Planning Application Ref: **AW/244/19/T**

Location: **Ravenwood Court, Aldwick Street, Aldwick, PO21 3AW**

Description of works: **Crown reduction approx. 2.5m and remove small dead limbs to 1no. oak tree, 1no. beech tree and 1no. London plane tree**

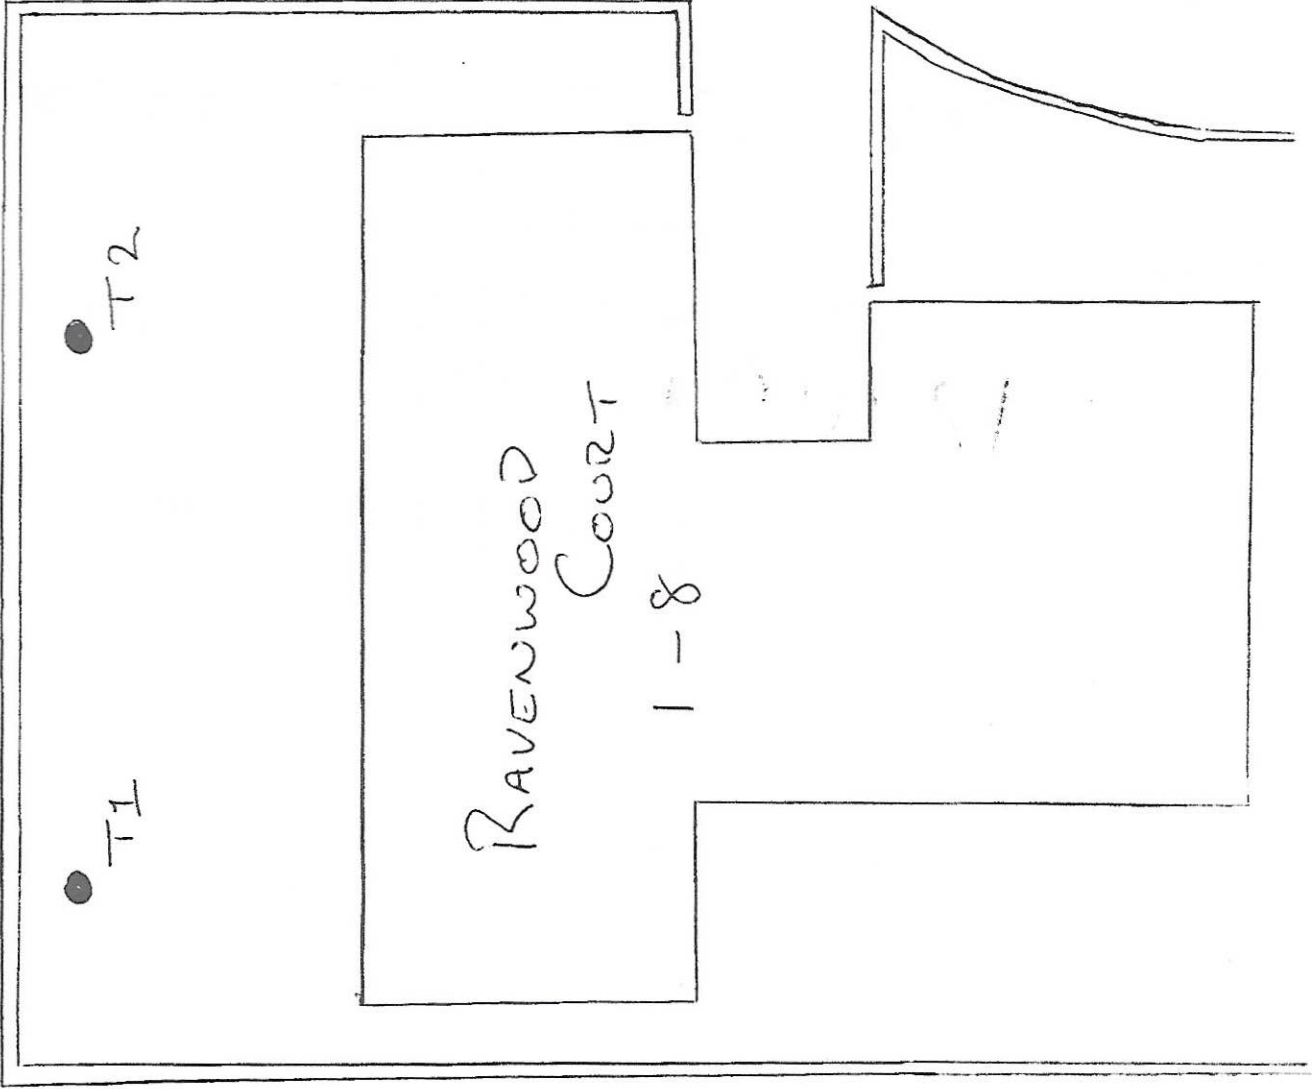
- T1 – Outwardly this tree appears to be in a fair physiological state and stable. Moderate upper crown density and relatively high deadwood content suggests a degree of stress. Prominent at the front of the property and visible to users of the public highway (footway and carriageway).

- T2 - Outwardly this tree appears to be in a fine physiological state and stable, with an attractive crown profile. Prominent at the front of the property and highly visible to users of the public highway (footway and carriageway).

- T3 - Outwardly this tree appears to be in a fair physiological state and stable, although woodpecker holes at approx. half-height are worthy of investigation to assess extent of cavity information if not already undertaken. Grows on the fringe of a valuable grouping, with correspondingly 'drawn up' and slightly irregular form. Discreet as an individual but an important constituent.

- There is an intention to improve light levels into the property and while the trees could be perceived as oppressive for some residents, most of their crown spread is to the north of the property and so there is unlikely to be any significant light occlusion.

- Direct interference with adjacent buildings from branches is becoming problematic and could be satisfactorily attended to with a sympathetic pruning operation rather than *crown reduction* which by definition involves the reduction of height and lateral spread on all aspects.

- The proposal to reduce the lateral extent of branches on specific aspects to maintain reasonable clearance of residential dwellings is justified and well-intentioned, but the work description is open to interpretation and so there is a risk of excessive work being permitted.
- It is necessary to clarify the work proposal so that we can be confident it will address the tree's potential impact on residential property whilst retaining their visual amenity value by having respect for natural tree form.

- As it stands, I recommend **REFUSAL** for this application.

- I would like to see the applicant submit a revised work specification such as detailed below, which would seem to address their concerns whilst preventing a diminution of the tree's landscape and public amenity value:
 - T1 Reduce selected branches to achieve a maximum of 1.5m clearance from adjacent buildings
 - T2 & T3 Reduce selected branches to achieve a maximum of 2m clearance from adjacent buildings
-

- If the applicant is prepared to re-submit in line with this advice, then I would be able to recommend APPROVAL subject to the following conditions:

- Where whole branches are to be removed and final cuts made close to the trunk or branch union they are to be made as shown in Figure 2 of BS3998:2010
- Where branches are to be shortened back the final cuts are to be made at the correct angle shown in BS3998:2010 and adjacent to a live bud or lateral.
